**WEST SUSSEX COUNTY COUNCIL
HIGHWAYS AND TRANSPORT SERVICES CONSULTATION**

DATE: 16th January 2008

SUBJECT: LU/455/07 - 3 industrial units formed by division of existing unit, re-clad to match existing with new entrance doors, windows & roller shutter doors.

Littlehampton Marina, Unit 2B, Ferry Road, Littlehampton, West Sussex

Block Plan
Scale 1:500

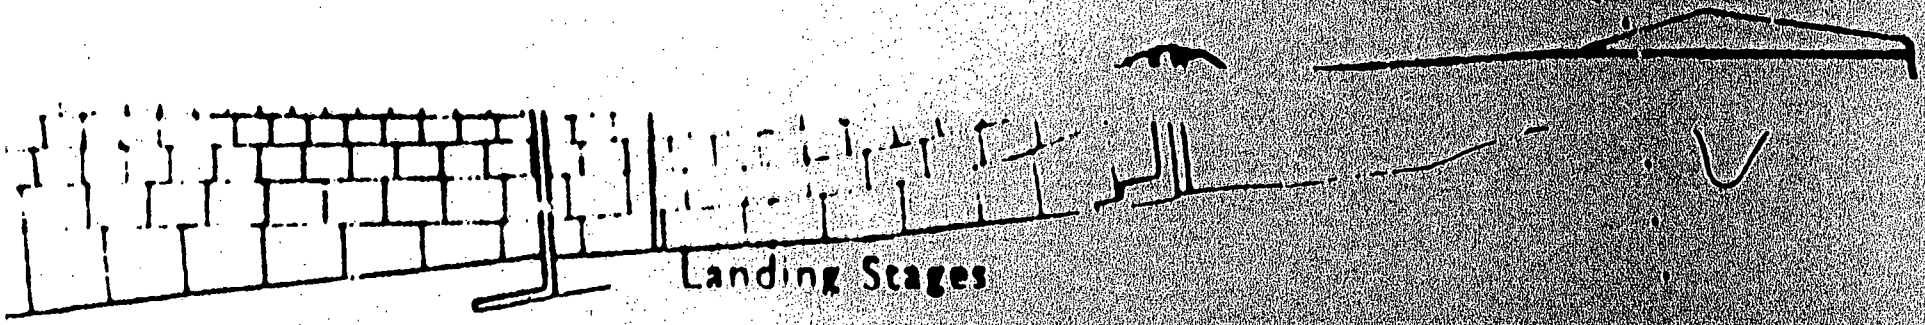
It is noted that no information has been provided in respects of car parking for the existing or subdivided units. Given that the overall floor area is not to change, nor would I anticipate the use of the buildings being intensified, no additional parking spaces would be required. However I do note that additional roller shutter doors are proposed on the southern elevation and these may result in the loss of some existing spaces. I see no reason why replacement spaces could not be created along the northern side of the building however and details, if appropriate secured via condition.

No highway objection would be raised.
